STATUTORY PLANNING CONSULTATION RESPONSE

Application Number:	3/2026/0400
Proposal:	Approval of details reserved by conditions 15 (surface water operation and maintenance); 16 (surface water verification report); and 17 (new build units verification) on planning permission 3/2022/0966.
Location:	Crow Trees Farm Crow Trees Brow Chatburn BB7 4AA

Client: Pringle Homes
Project: Crow Trees Farm, Chatburn
Drawing Title: Foul and Surface Water Drainage Plan

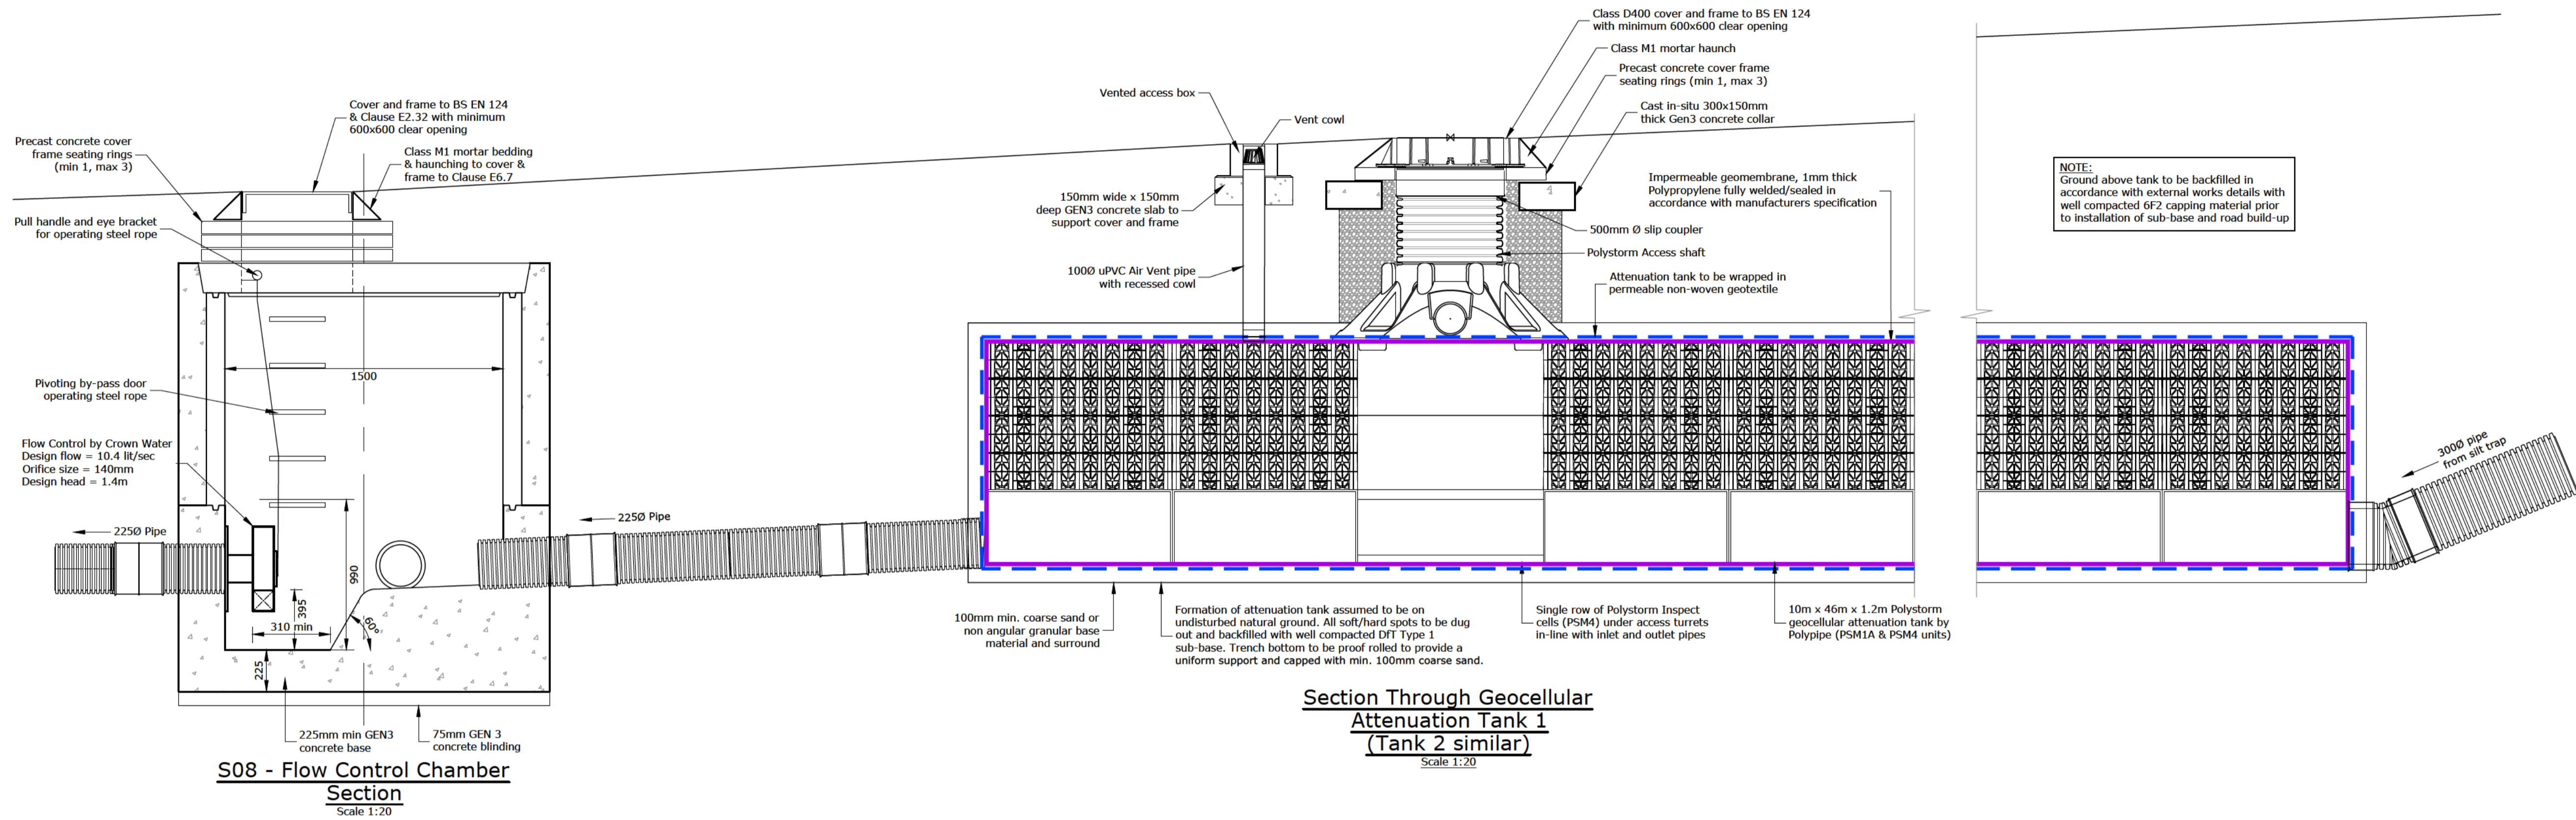
- The Local Planning Authority should satisfy itself that the applicant has put the appropriate measures in place and mitigate against residual risk given the applicants alterations, and having a combined surface water and foul drainage connection. The applicant has met the wording of the aforementioned conditions, however the applicant has proposed that a non-return valve is not required, despite the combined connection point (C03) showing that the foul water entering this chamber at a higher inlet level than that of the surface water, meaning that should a blockage or problem occur between C03 and C02, and the system were to start backing up, foul water has the potential to backup along the surface water drainage system, which has inherent risks.

For the avoidance of doubt, the applicant has not given evidence of a simulation model of the two systems combined up to the final outfall, given that these systems now have the potential to interact and affect each other.

It is widely acknowledged as the industry standard as to drain foul and surface water on separate systems, this deviation, should have been highlighted at a much earlier stage and assessed or re-assessed through the final detailed surface water sustainable drainage design and/or condition, as this change has the potential to affect the drainage of the development and its associated flood risk if not managed appropriately.
